DECISION DELEGATED TO HEAD OF PLANNING

Application No: H09-0563-25 **Applicant:** Mr S Hassan

Proposal: Change of use of part of existing car wash to restaurant (Use Class E) and take away (Sui Generis) with installation of extraction flue system, new shop front and rear single storey extension

Location: Land East Of Boston Road South (Formerly Jewson Ltd) Holbeach Spalding

PROPOSED SITE PLAN  
SCALE: 1/500 @A3

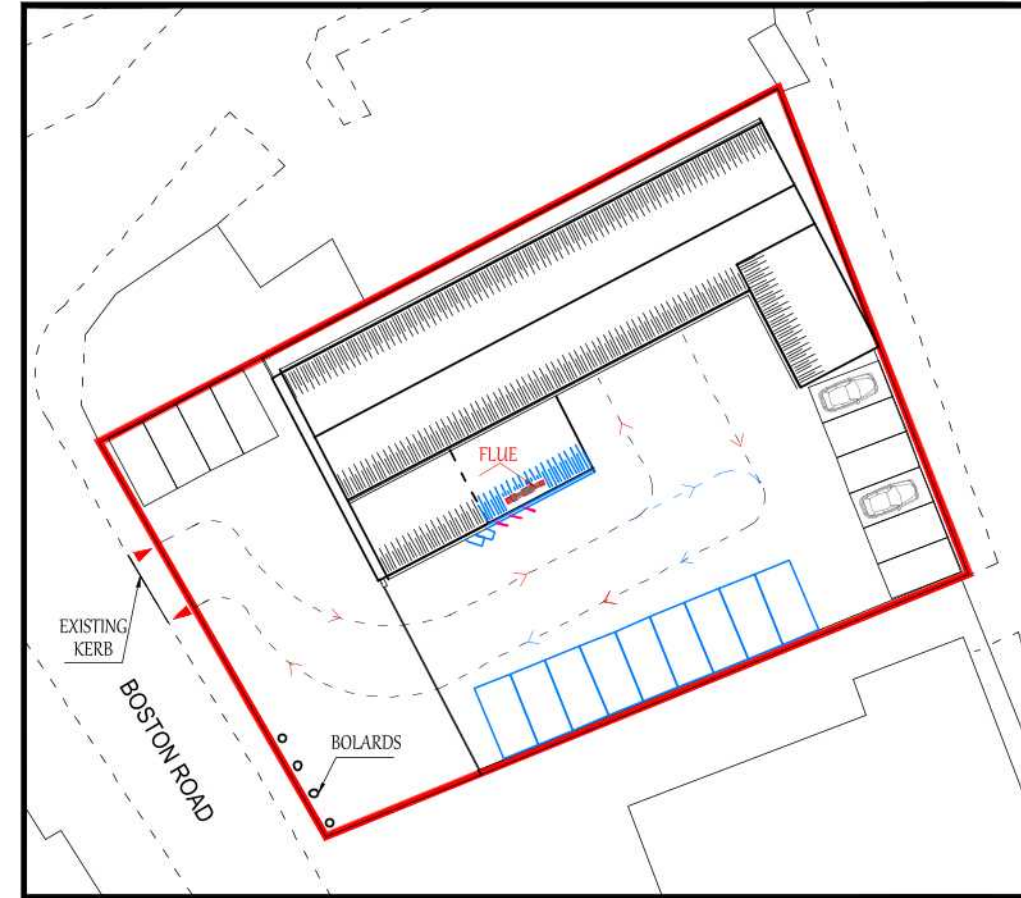
Lincolnshire County Council: Highways and SUDS Support: The car wash has parking to the front, but the proposed site plan does not show this. The Design and Access statement says about cycle parking and scooter parking for deliveries, but they are not detailed on the proposed site plan. Parking justification is required and spaces to be detailed on plan.

Under permission H09-0590-24, the approved site plan proposed six parking space at the rear of the site, and two parking spaces next to the building, where the rear extension is proposed under the current proposals. This would result in the provision of six parking spaces for the car wash business, rather than eight spaces.

The submitted application form for the current application indicates that 10 parking spaces are within the site and 10 spaces are proposed. However, initially the site plan showed no parking spaces. This was queried with the applicant as Lincolnshire County Councils (LCC) Highways Team also requested further details, including the proposed car parking arrangements. Subsequently, an amended site plan, ground floor plan and roof plan were provided showing the proposed parking spaces. Within the amended plans, 15 car parking spaces are shown within the car park area towards within the rear section of the site, and five parking spaces are shown near the site entrance.

PROPOSED FRONT ELEVATION  
SCALE: 1/100 @A3

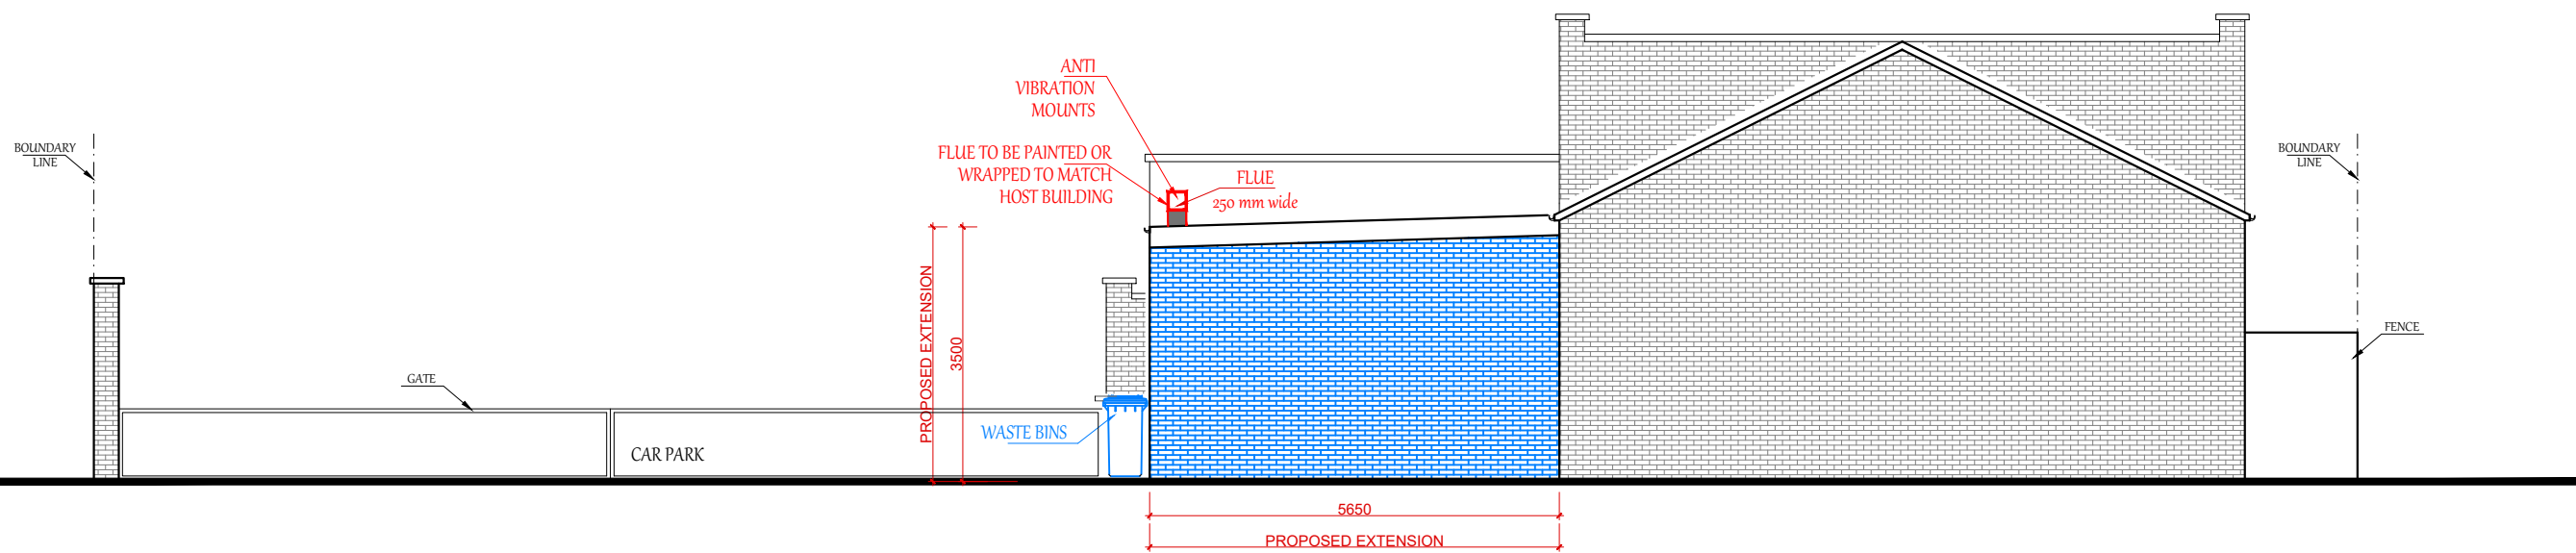
A glass paned shopfront window is proposed on the western elevation of the building, which fronts Boston Road South. Currently this elevation forms part of the car wash business that was granted approved under reference H09-0590-24. The elevation is set back from the road frontage and the site already features a commercial character. It is considered that the proposed shopfront would have an acceptable visual impact on the street scene.

A single storey rear extension is proposed on the existing building within the site. The proposed extension would result in the loss of two parking space that were approved under permission H09-0590-24. The impact of this in highway safety terms is considered later within this assessment. The extension is proposed to measure 7.8 by 5.6m. The extension is proposed to feature a flat roof, continuing the roofline of the existing building. As such, the extension would measure 3.6m in height. The scale and siting of the extension is considered to be proportionate to the host building. Part of the external flue extraction system is proposed on the roof of the extension. This would be screened from view at the front of the site due to the positioning of a taller wall along the frontage of the building. The flue would, however, be visible from the street scene further to the south of the site. The visual impact of this is considered to be acceptable on balance given the small-scale nature of the flue.

The application form indicates that the external materials for the extension include 'thermal block and brick'. It would be considered appropriate to include a condition requiring the external brickwork to match the existing brickwork as closely as possible in the interest of the visual amenity. Therefore, the visual impact of the proposed extension is acceptable.
